ATLASSIAN CENTRAL

Response to Submissions -
Heritage & Archaeology

Associate Director Heritage	Ashleigh Persian, B Prop Econ, Grad Dip Herit Cons, M>ICOMOS		
Project Code	P0020770		
Report Number	01	20.04.2021	Draft
	02	03.05.2021	Final
	03	07.06.2021	Revised final

DRAWING
SHED - SOUTHERN
ELEVATION
DOCUMENT NUMBER
DA-11C-GXX-02
ISSUE
6

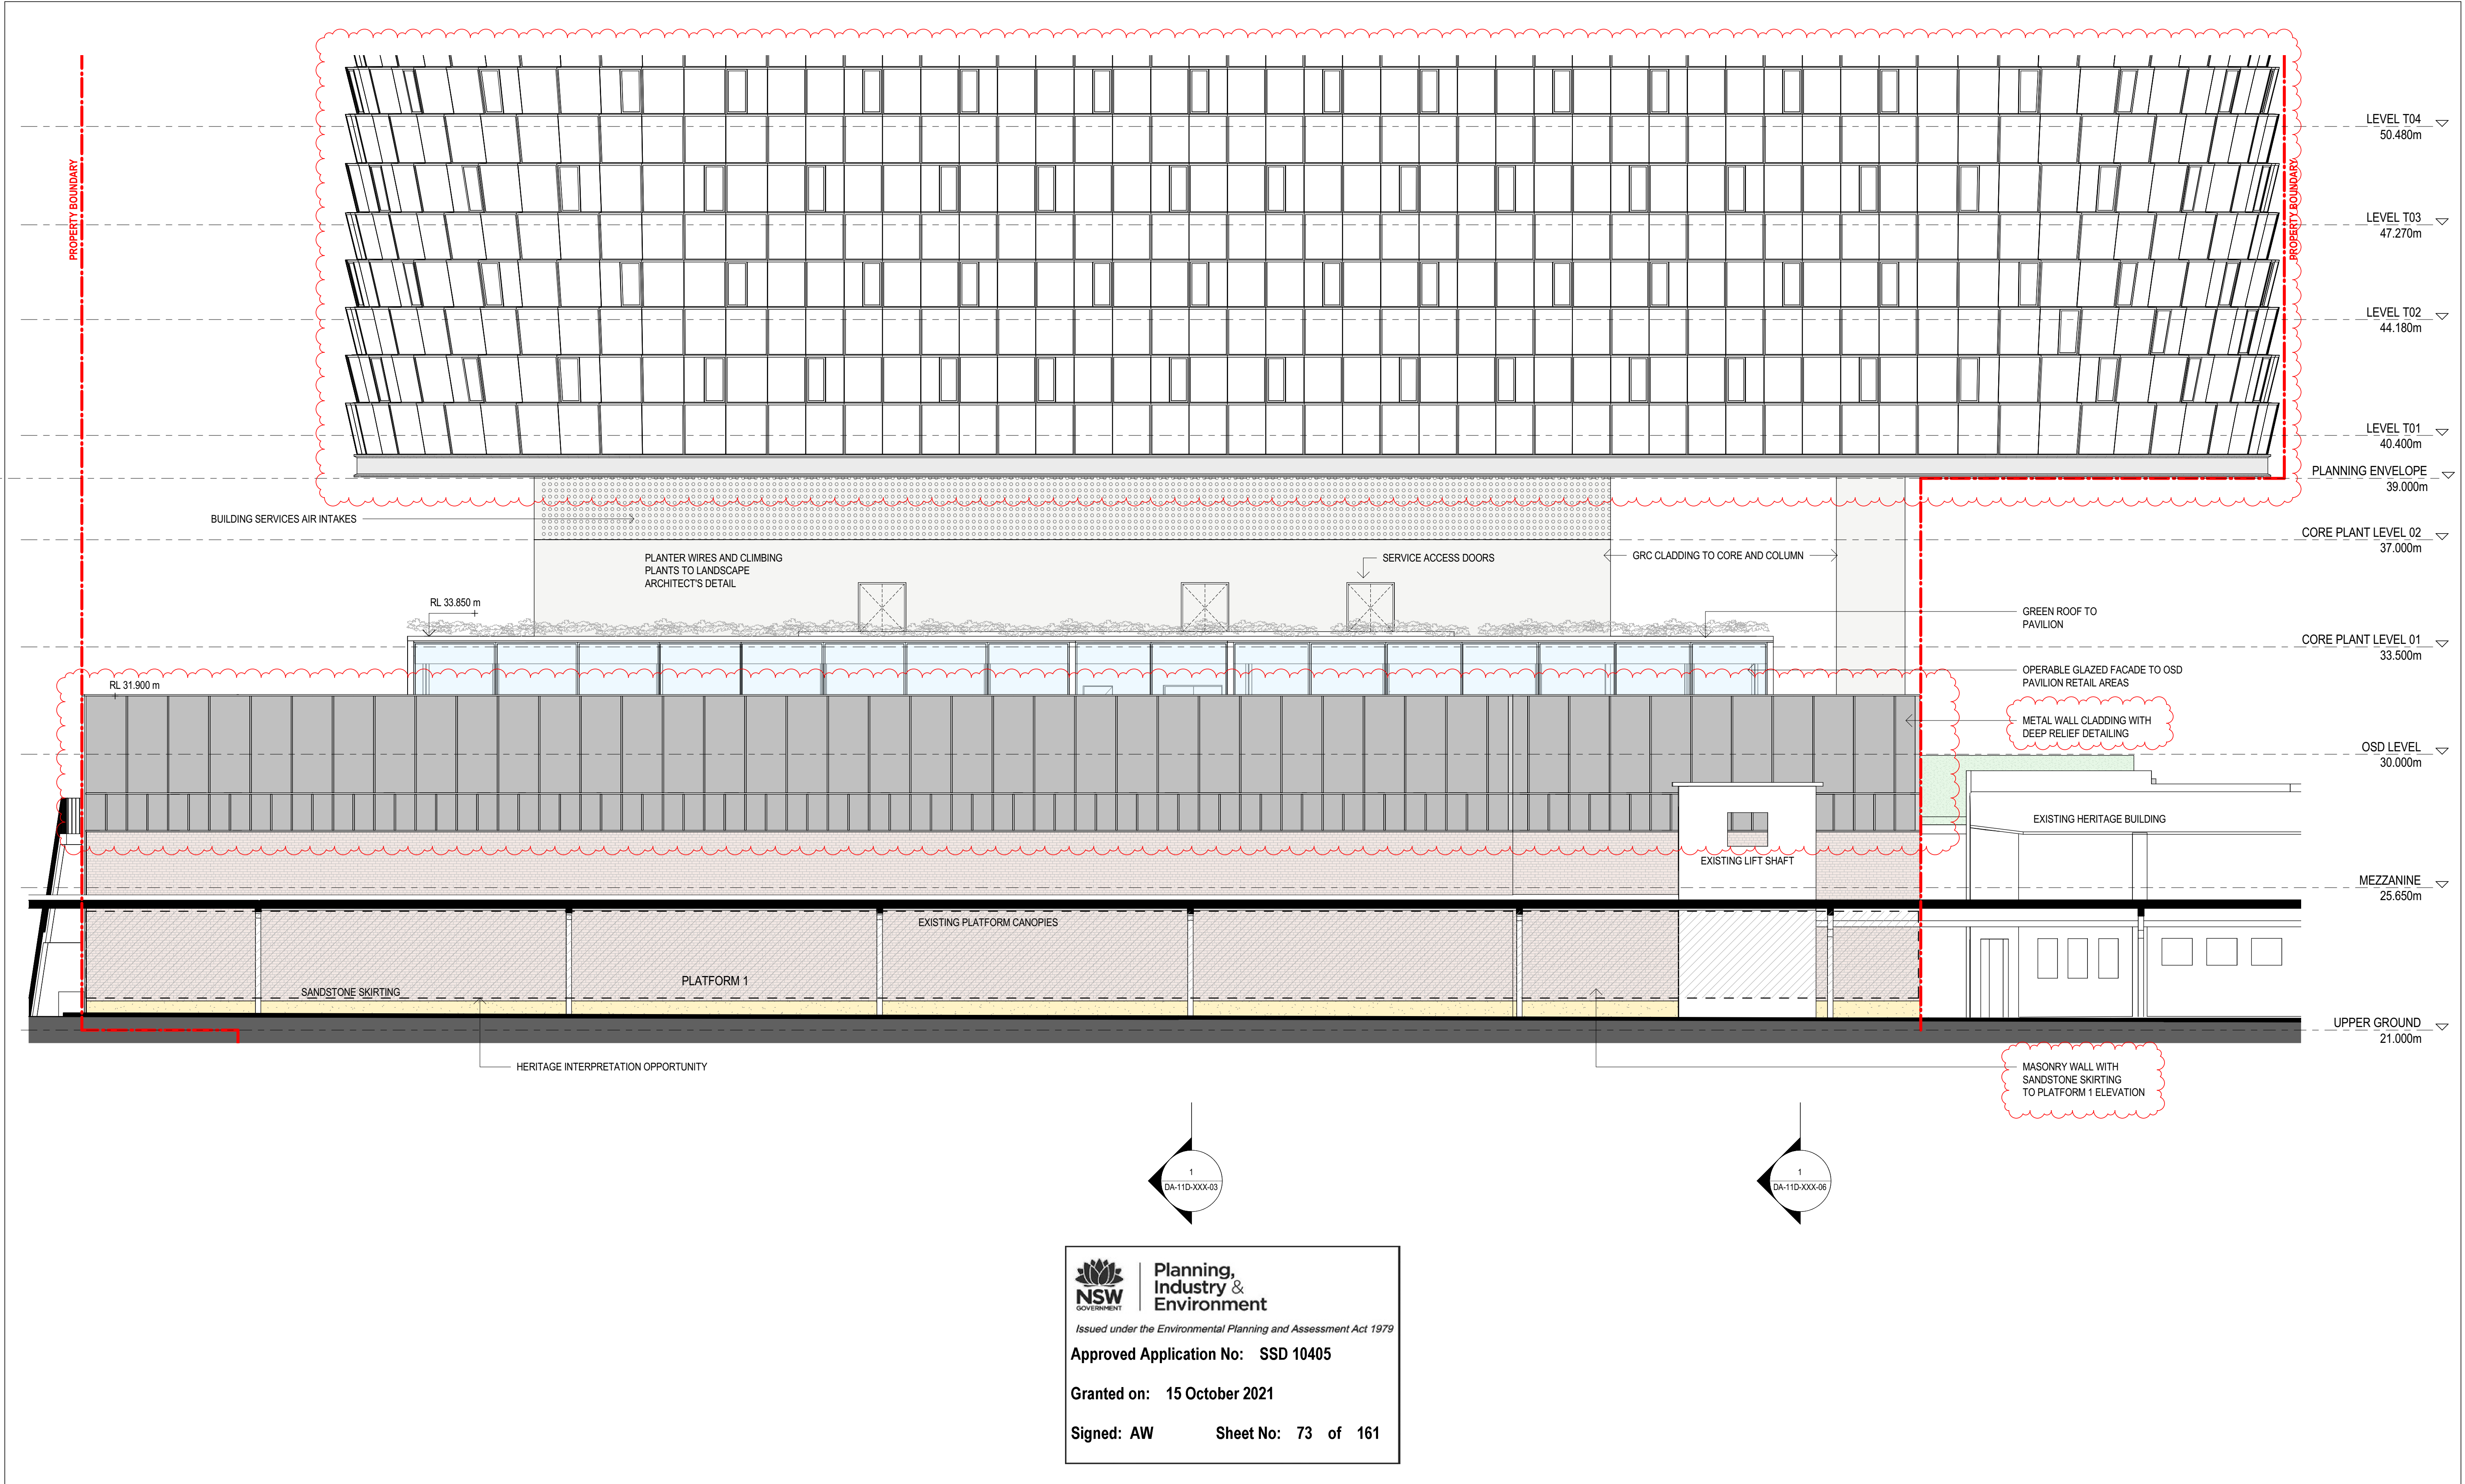
<p><i>The visual impact of the large glass cladding of the shed on northern elevation is uncharacteristic, somewhat bland</i></p>	<p>Weatherboards or timber louvres do not reflect the architectural history of the building and would not be</p>

Submission	Urbis Heritage Response
<p><i>and looks unfinished. In addition, considering the north orientation, it will negatively impact on energy performance.</i></p> <p><i>A preferable solution may be to undertake an interpretative re-construction. The original windows could be refurbished and returned to their original locations in the elevations. The areas of (formerly solid weatherboard) walls surrounding them may be glazed but clad with build external timber horizontal louvres based on the proportions and materiality of the original weatherboard cladding. This can deliver an appropriate level of passive sun control and present a more solid appearance more consistent with the original building. This would allow clear glazing and so would allow very good visual connection between the interior and exterior in all lighting conditions.</i></p>	<p>appropriate for the northern elevation. Further this would obscure the original building frame.</p> <p>A number of options were explored for this elevation including a louvred option, however for a number of reasons including fire separation compliance and climate control, louvres for this space were not feasible. Further the wall is located on the boundary and installation of louvres would require an overhang and further property titling arrangements.</p> <p>The preferred solution is the installation of a fritted glass or louvred glass to the areas where the shed was historically clad in corrugated metal. The texture of these glazed solutions means that natural light can be accessed within these new principal entrance spaces, and a visual relationship between the future town square and the character of the subject shed can be established. This glazing will allow users of the precinct to engaged with and interpret the original timber structure of the shed and celebrate its history and significance.</p> <p>The existing windows will be retained with clear glazing inserts to distinguish this area from the formerly corrugated metal clad area of the elevation.</p>
